Our reference: ECM: 8965012
Contact: Gavin Cherry
Telephone: 4732 8125

28 January 2020

SSD 7348 - MOD 2 - Further Amendments to Concept Plan and Stage 1, Oakdale West Precinct

FOR BUILDING 1A - REFER TO DA DRAWING NO. OAK-1A-DA-10

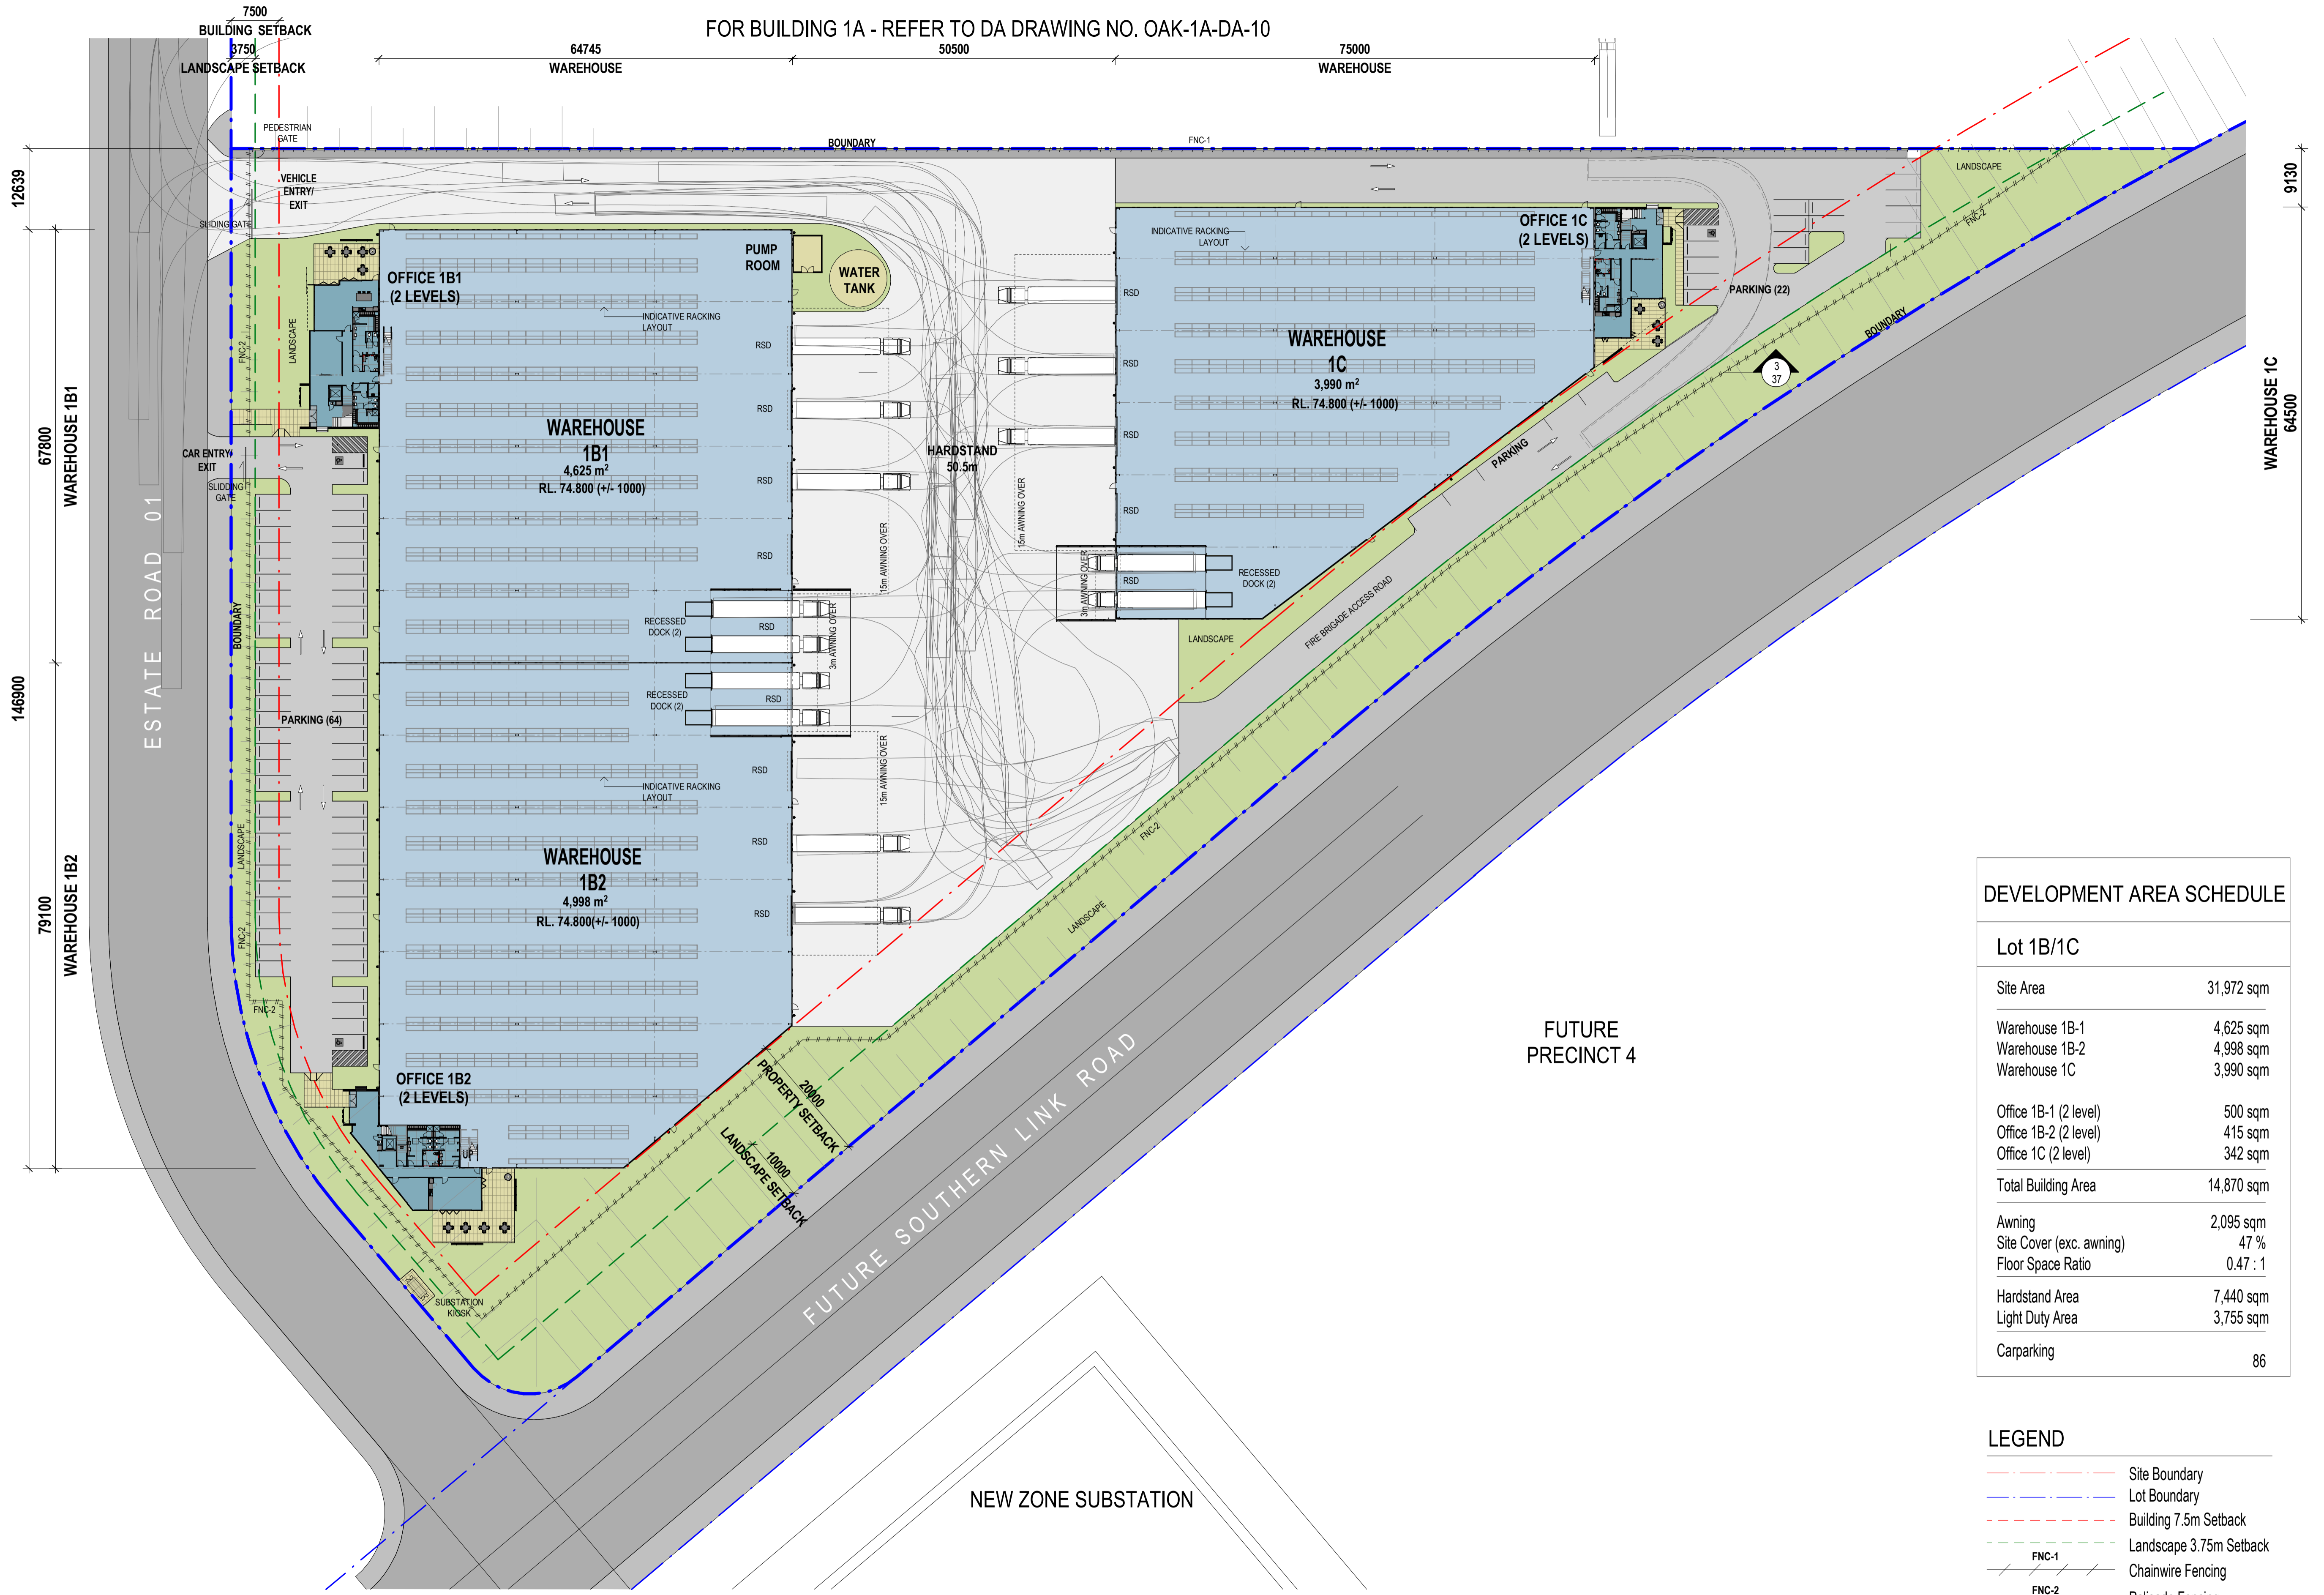
This amendment will necessitate redesign of the Site1B car parking area fronting Estate Road 1, will likely amend internal manoeuvring between Site 1B and 1C and will likely necessitate deletion or significant amendment of Site 1C.

- 2.2 The manoeuvring area between Site 1B and 1C which is protruding into the Western North South Link Road landscaping setback should be deleted and reconfigured (as per above.). To reflect orderly and consistent development within the precinct, the approved arrangement and resulting landscape setbacks for Stage 3C and Stage 3D should be replicated within this part of the precinct. The current proposal provides an inconsistent and poor streetscape outcome that is at odds with the principles and streetscape presentation established in the approved concept plan. Any amendments now proposed should improve on the streetscape principles and delivery outcomes approved, and not compromise them.

- 2.3 Opportunities to remove / relocate parking out of the Western North South Link Road should be further explored. Line marked parking spaces and aisle extensions should be removed / relocated where they extend in front of the identified 10m landscape setback line. While it is noted that they are often point encroachments, the 10m landscape setback should be unencumbered. Essentially no parking or aisles should protrude forward of the green setback line on the architectural plans.
